Our Ref: SDNP/18/01298/ADJAUT

Neighbouring Authority Consultation

Proposal: FG/33/18/PL - amendment to the above application dated 17th April 2018 relating to:- SUP LETTERS AND IMAGE OF STORAGE CONTAINER - Demolition of polytunnels, use of land for Class B8 container self-storage & the siting of 42 No. single-stacked storage containers, an office/toilet portacabin, new fencing, gates, CCTV, lighting & alterations to the entrance.

Address: Land at Former McIntyre Nursery , Littlehampton Road , Ferring , BN12 6PG

TITLE PROPOSED SITE & BLOCK PLAN	DWG NO 5285-2	REV C
--	-------------------------	-----------------

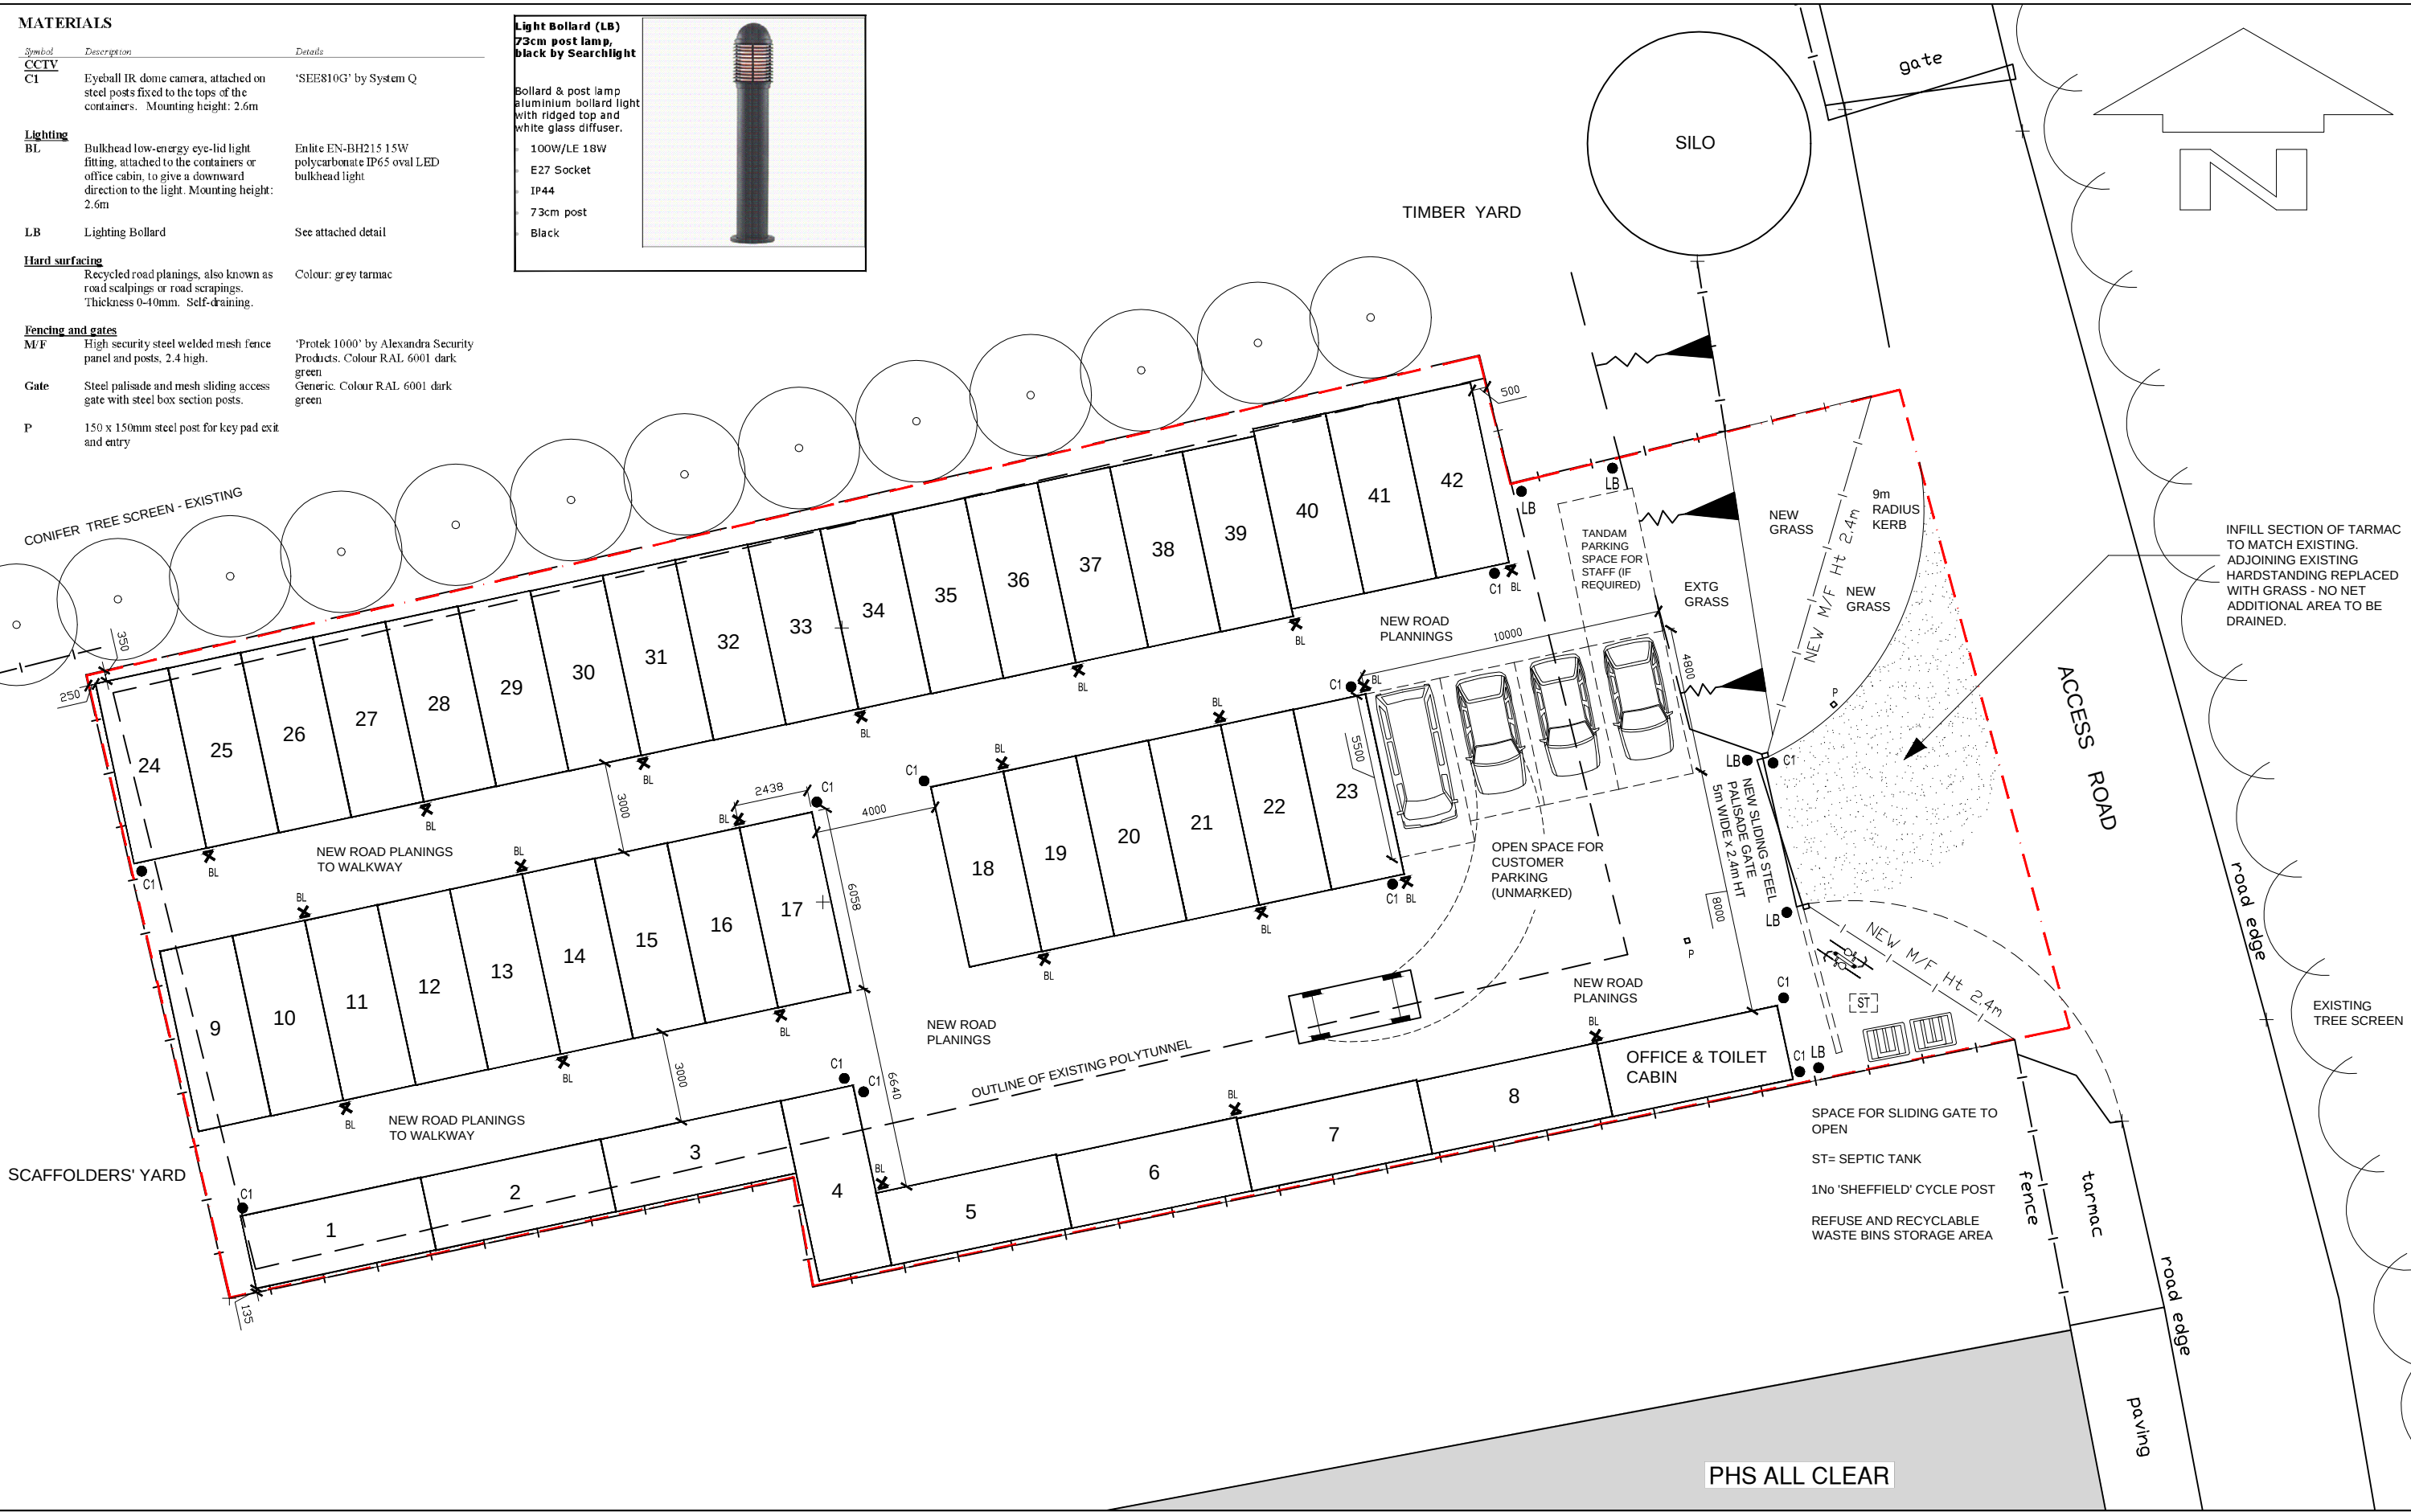
Within the submitted Planning Statement it outlines that the proposed containers would be limited in height and green in colour and that a single stack is proposed. It is recommended that a condition is attached to any permission granted to ensure that the containers are stacked as single containers at all times and sample panels should also be secured through a condition for the colour of the containers to ensure that the chosen colour blends in with the landscape as much as possible.

However, it has not been possible to ascertain from the lighting assessment and the fixture detail submitted how the oval light would be fitted with an eyelet, as the producer doesn't seem to give that option. Without any eyelets, these lights, although low powered, would throw light upwards above the ILP limit of around 2.5% for this area (E2) or 5% for an urban zone. The lighting design seems to suggest 50% if installed at the horizontal at the top of the container. This implies that 50% of the light would be wasted as it would be going above the containers.

It would therefore be better to install lighting that projects all lighting downwards so that the upward light ratio is zero. This is however difficult to achieve with the current design.

Also, from a wildlife perspective, a colour temperature of around 3000K is more preferable than whiter lights.
